CONCEPTUAL SITE PLAN  
MULTIPLE PARCELS

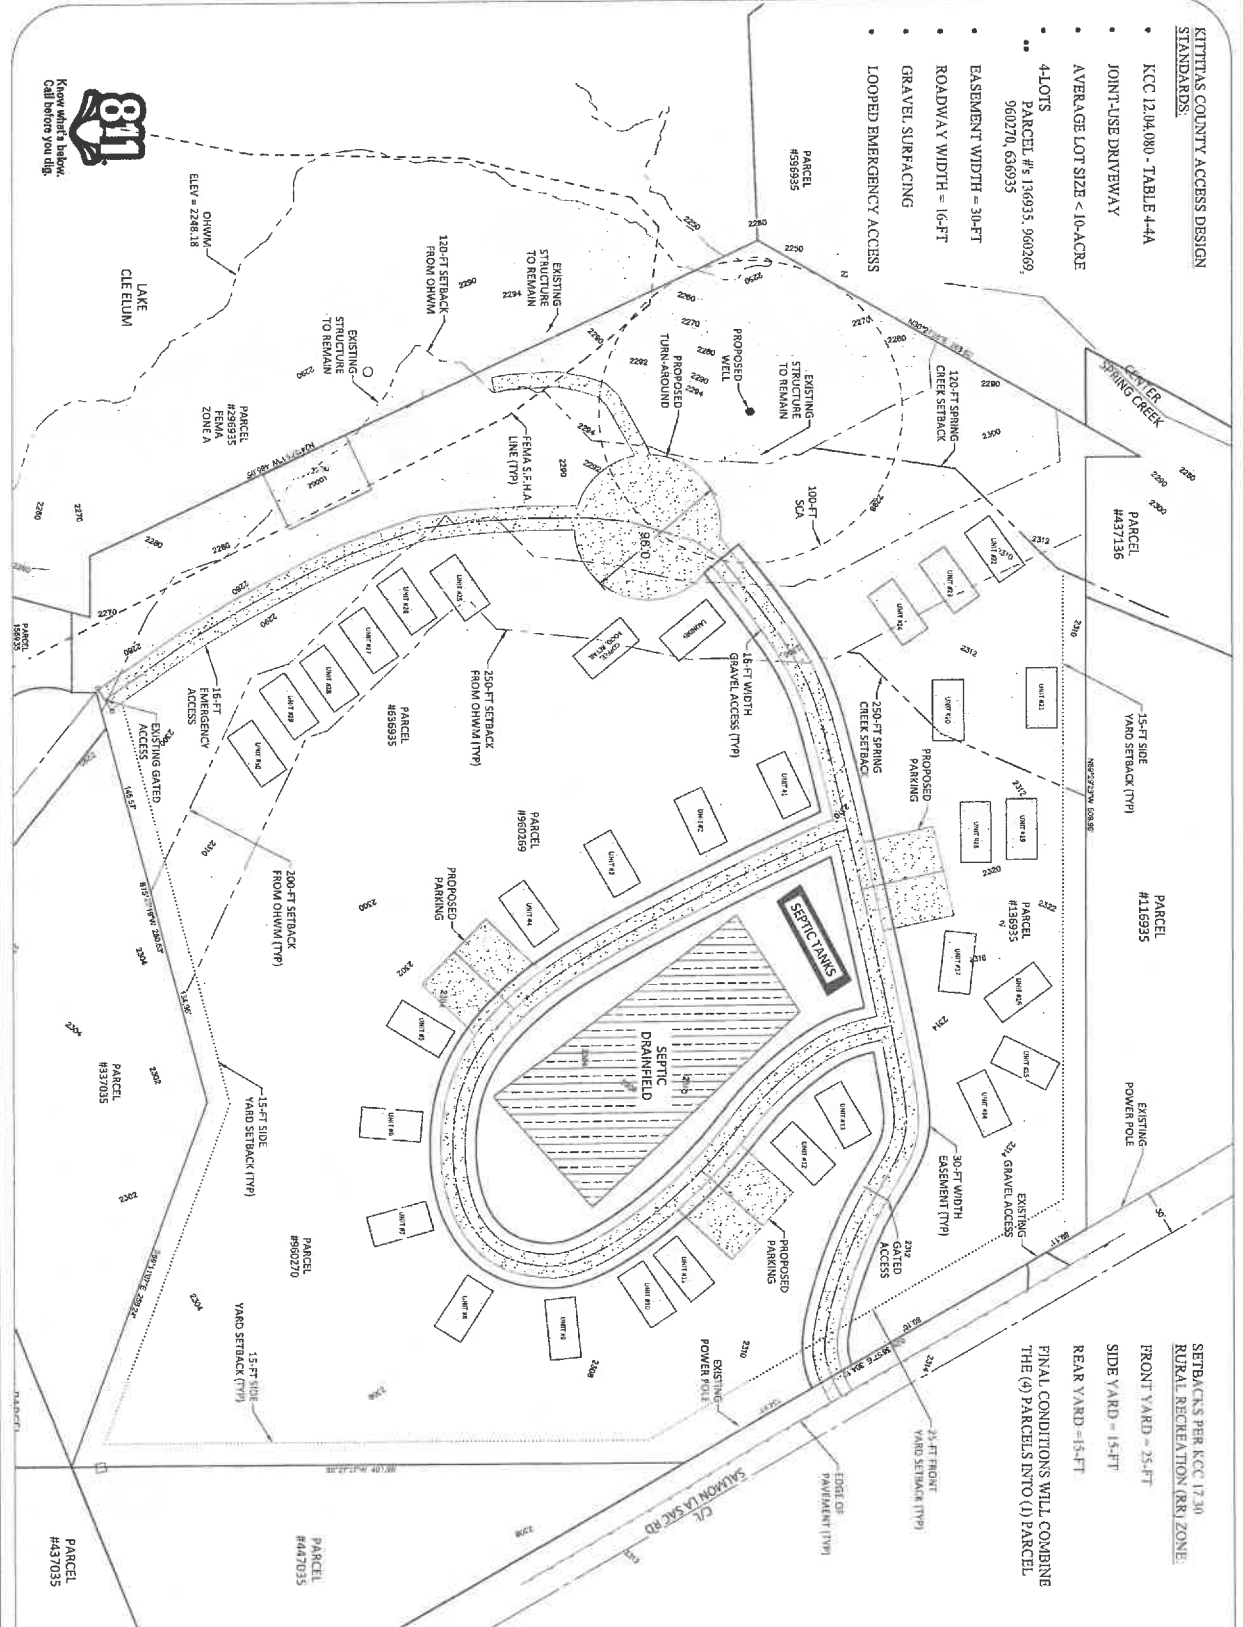
- There are many large trees on this property. To state ***only small trees*** will be removed would be difficult, if not impossible, to accomplish when building the proposed structures. How is the developer to be held accountable to their response?

- 1 parking space per cabin with an additional 5 extra spaces. 1-2 grounds/caretaker designated to the project year-round, this leaves even less. To think every camping unit will come with only one car is not accurate. Also, if campers have recreational vehicles, where will they park them?
